Ribble Valley Borough Council
Housing & Development Control

Application no: **3/2021/1262**

Address: **Land at the North of the Chapel Hill site Longridge**

Proposal: **Full application for the erection of 4no. commercial units (Use Class E).**

**PLANS & ELEVATIONS AS PROPOSED**

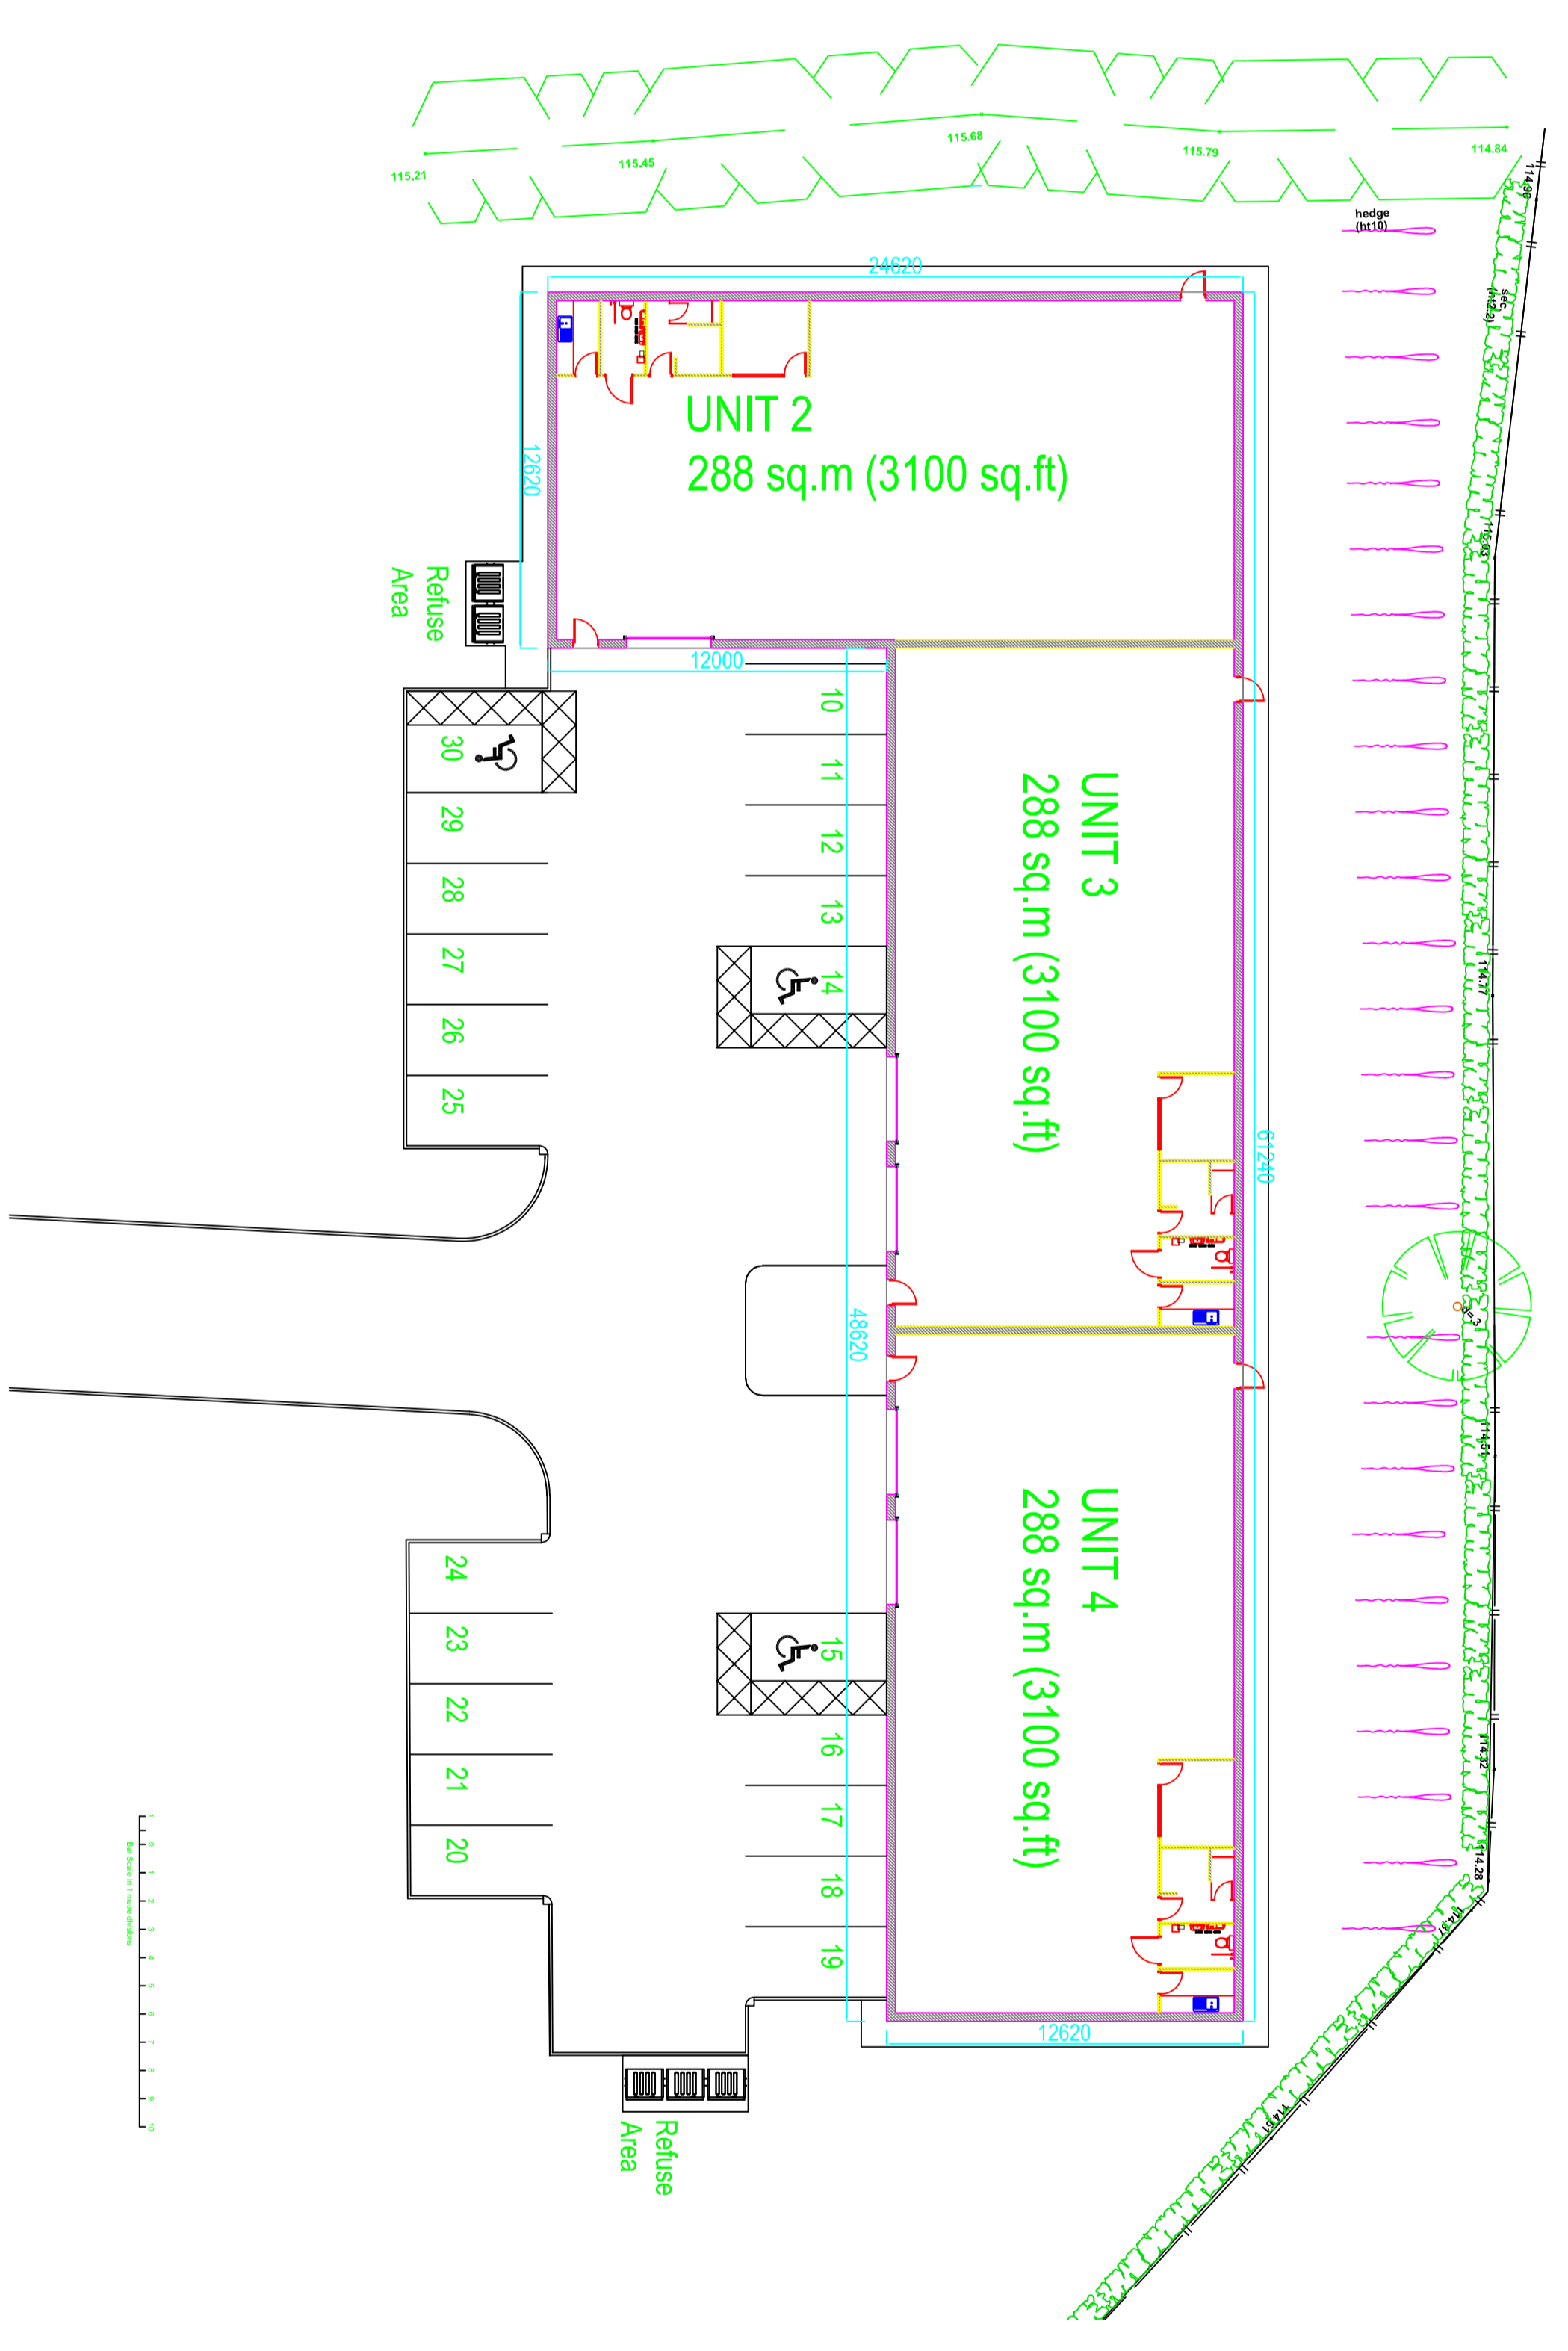
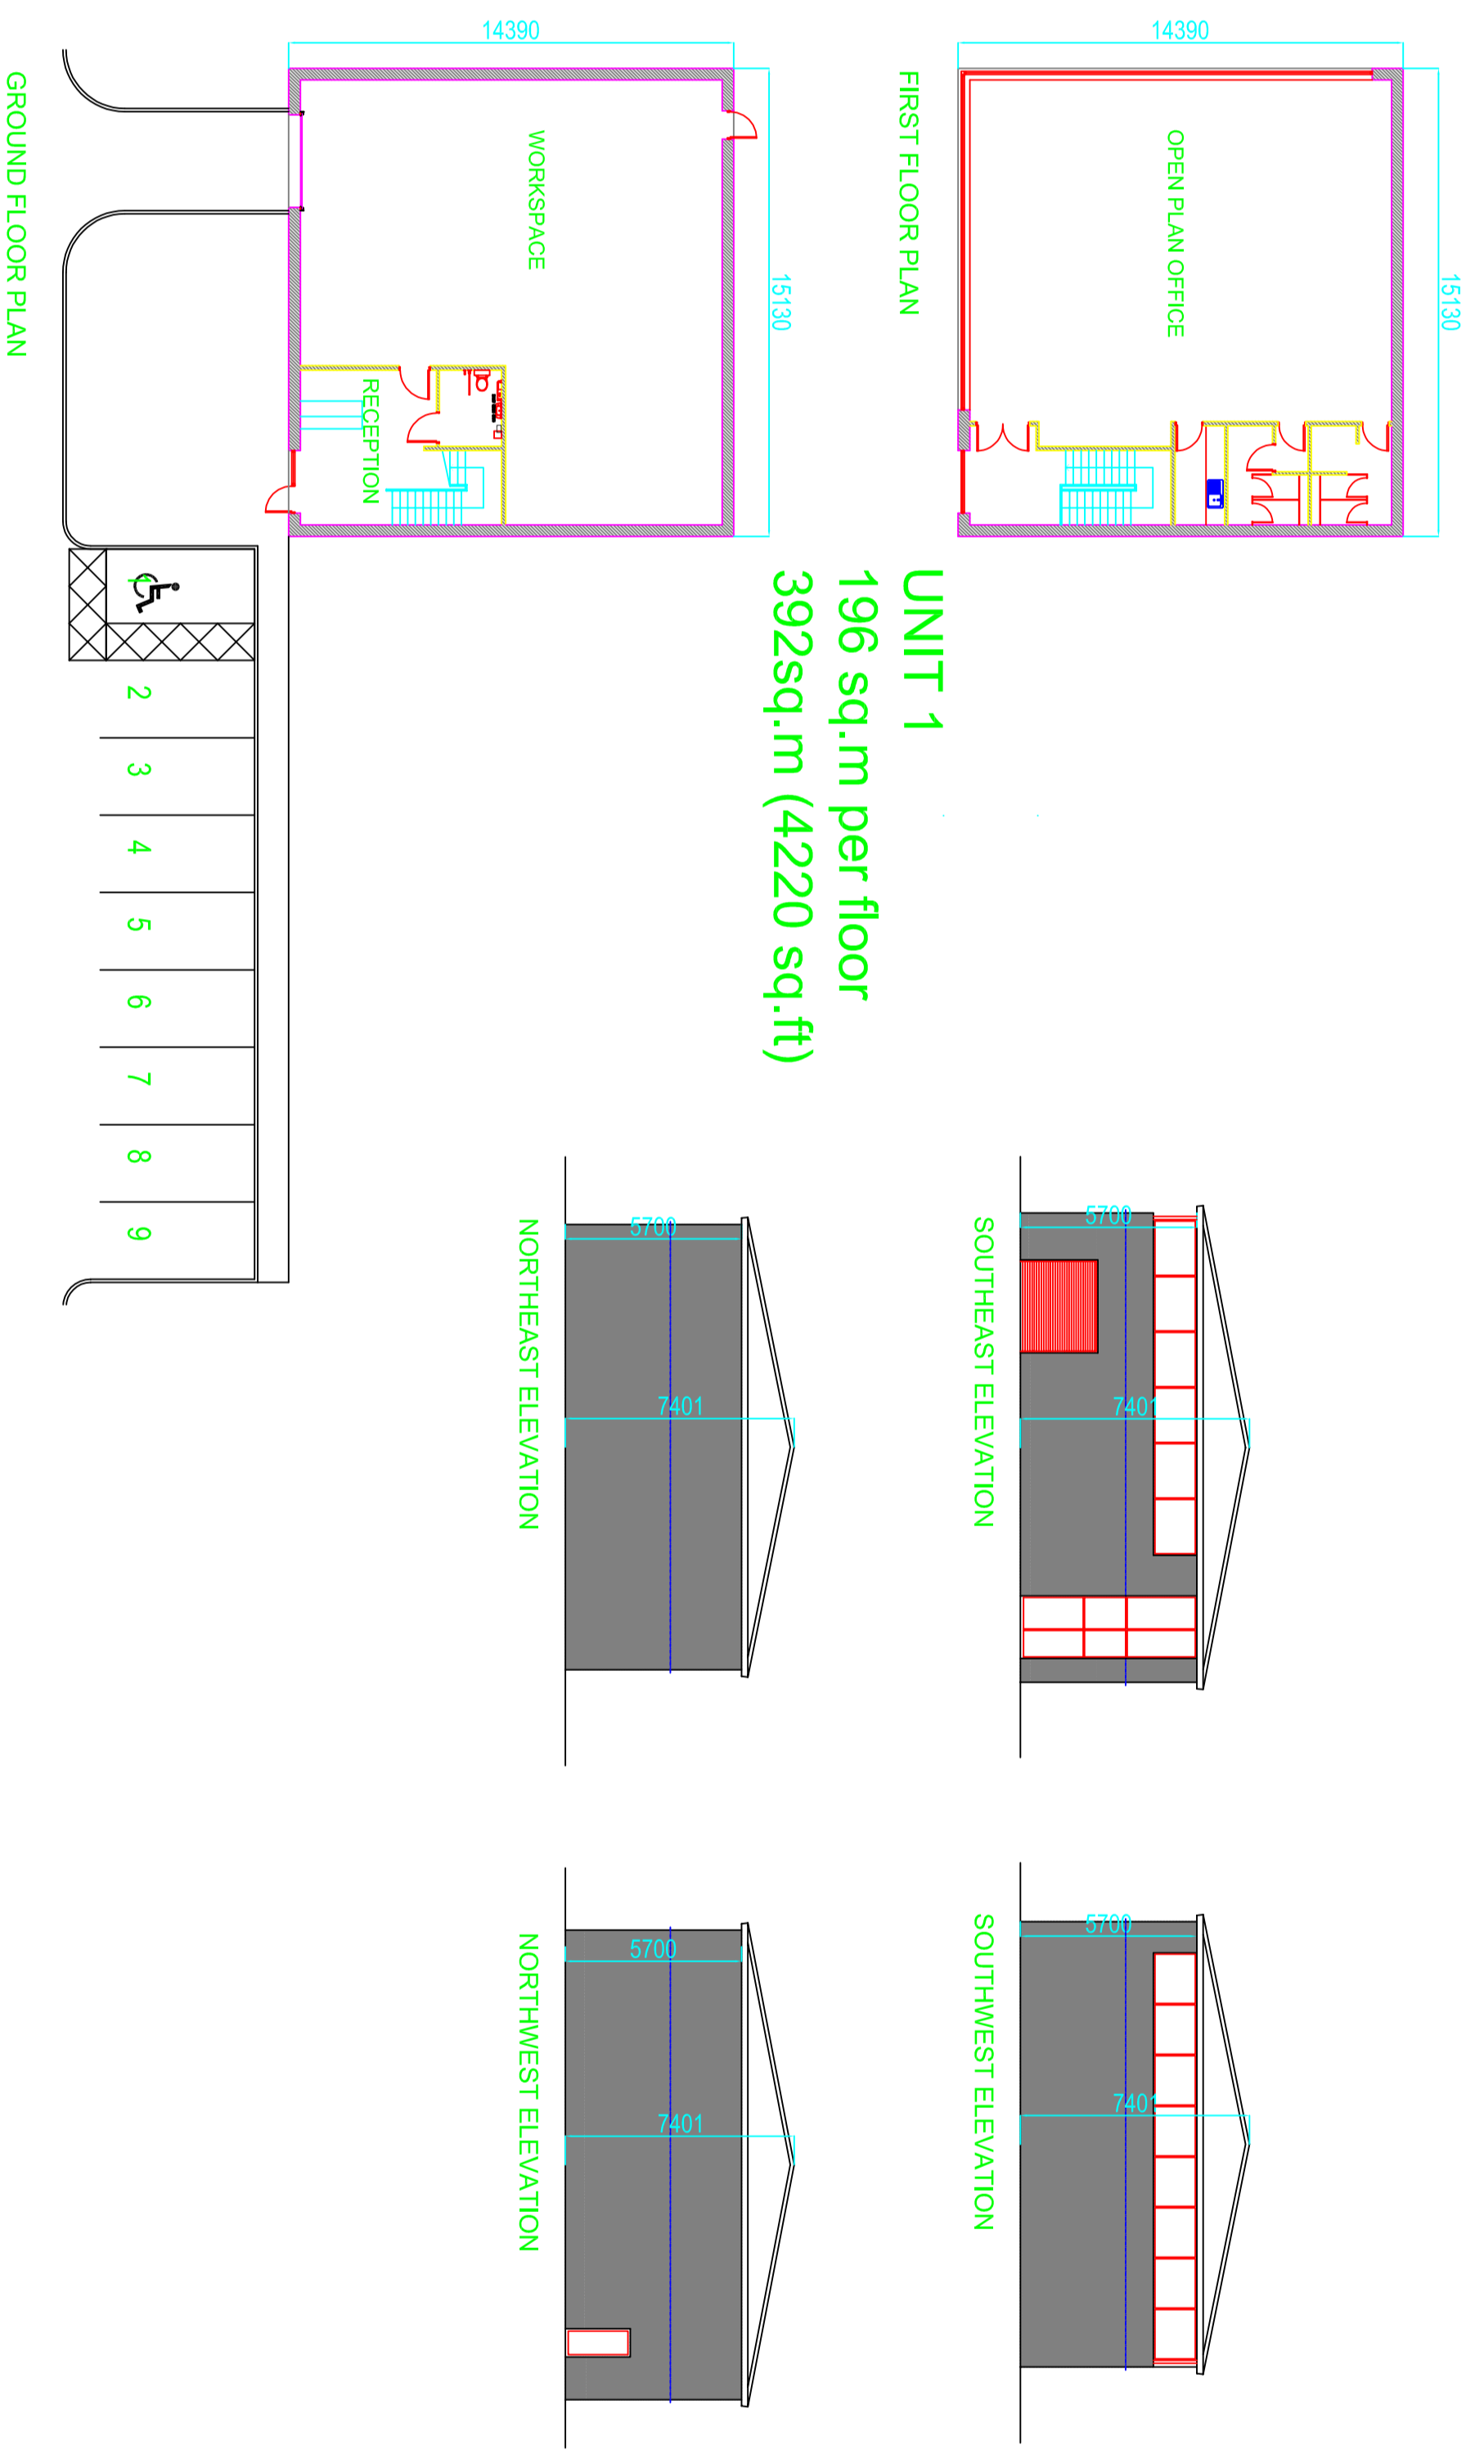
The LHA have reviewed IP drawing number 3 Rev C titled "Plans and Elevations As Proposed" and are satisfied that the access width and the visibility splays shown in the Transport Statement, comply with the LHAs guidance. Therefore, the LHA have no further comments to make regarding the site access.

The LHA have reviewed IP drawing number 3 Rev C titled "Plans and Elevations As Proposed" and are aware that the site will provide 40 car parking spaces for the proposal. This complies with the parking standards found in the Joint Lancashire Structure Plan.

It is worth noting that the swept path which shows a large, delivery vehicle servicing Unit 3 will overlap the provided disabled space, which could cause conflicts to occur. However, the overlap of the disabled space can be managed on site by requesting anybody parked in the space to move their vehicle.

3.The development hereby permitted shall not be occupied until such time as the parking and turning facilities have been implemented in accordance with IP drawing number 3 Rev C. Thereafter the onsite parking provision shall be so maintained in perpetuity.
